Subject: FW: BR/131/20/PL, Land and Between 2b And 4 London Road Bognor Regis, PP-08781759

Subject: BR/131/20/PL, Land and Between 2b And 4 London Road Bognor Regis, PP-08781759

I am writing in connection with the above planning application which I object to.

JJR DESIGNS Limited

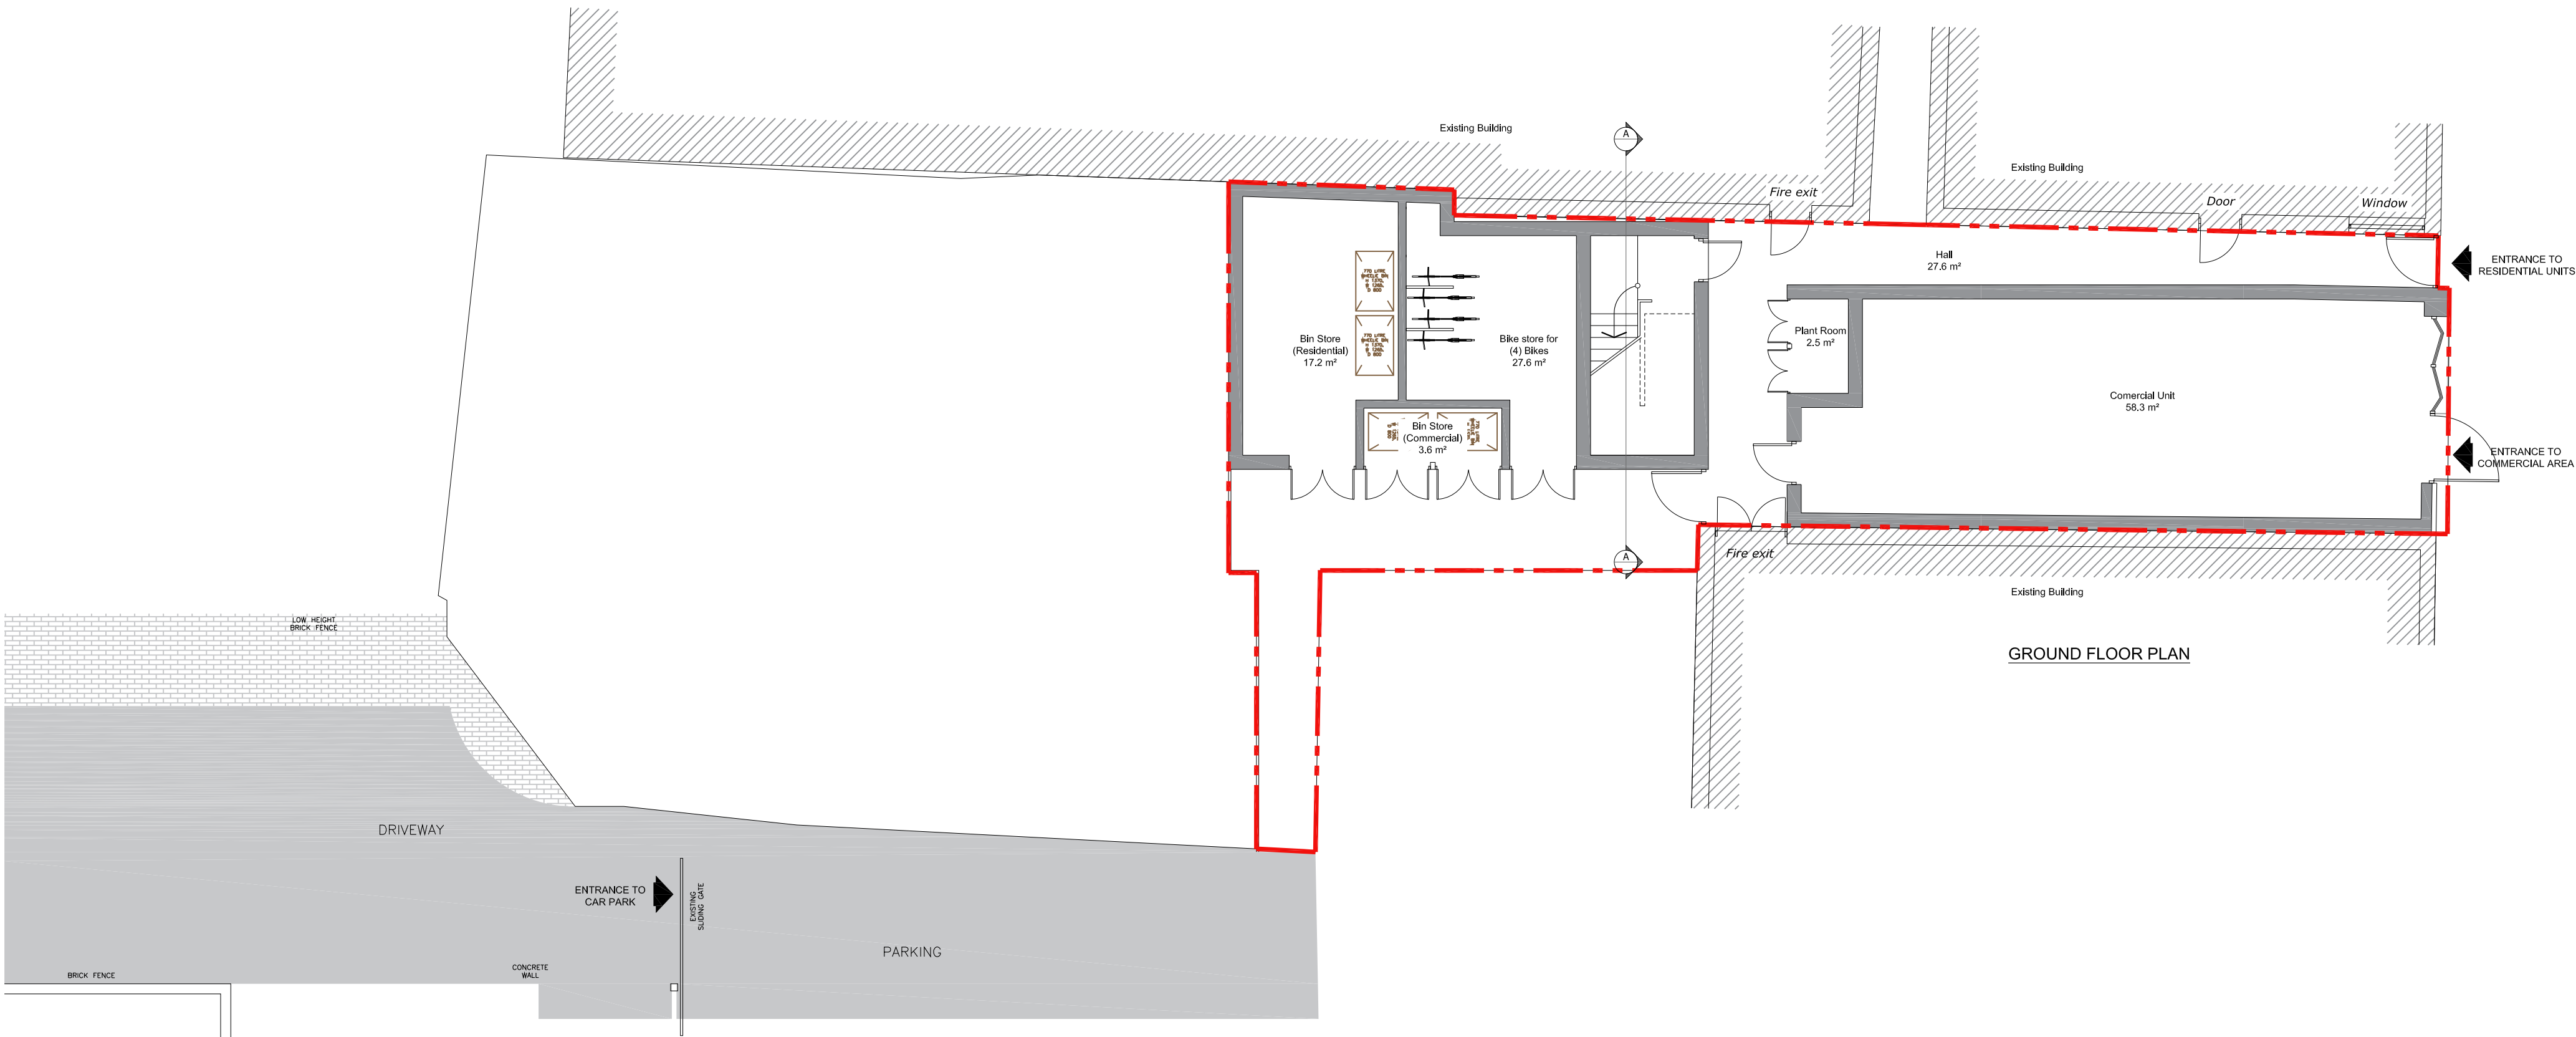
We have a High Court Order dated 1st November 1976 registered on our title deeds in our favour granting a Right of Way over this land which the adjacent owner intends to build over. Furthermore, this planning application would block the rear yard fire exit for our commercial units and also access to the bins.
